Charlestown Place SHD

Quality Audit - Stage 1

Puddenhill Property Limited

February 2021

Figure 5-3 - Charlestown Place Pedestrian Crossing Layout

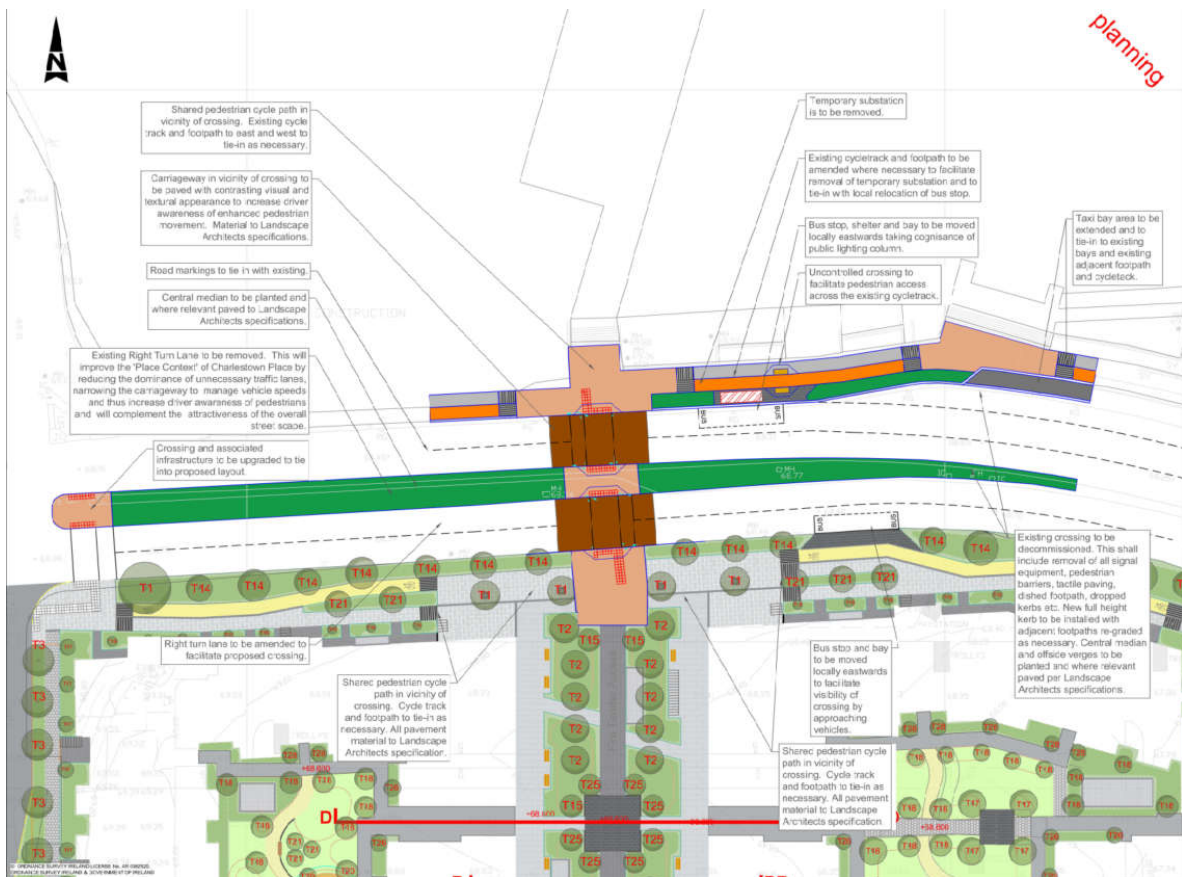
The alignment of the pedestrian and cyclist facilities either side of the shared crossing could result in collisions as users move from their desire lines to continue on their respective paths. This could lead to an increase in pedestrian and cyclist collisions resulting in injuries.

The Design Team should consider realigning the cycle track and footpath facilities on the east approach facilitate desire lines.

2.1	Y	N	To address this item, the layout has been amended to introduce the interface between the shared area and cycle track / footpath earlier on both approaches so as to allow pedestrians and cyclist more space and time to mix with one another in advance of the crossing. This will facilitate users to be familiar with one another's movement and desire lines and reduce potential conflict.	Y
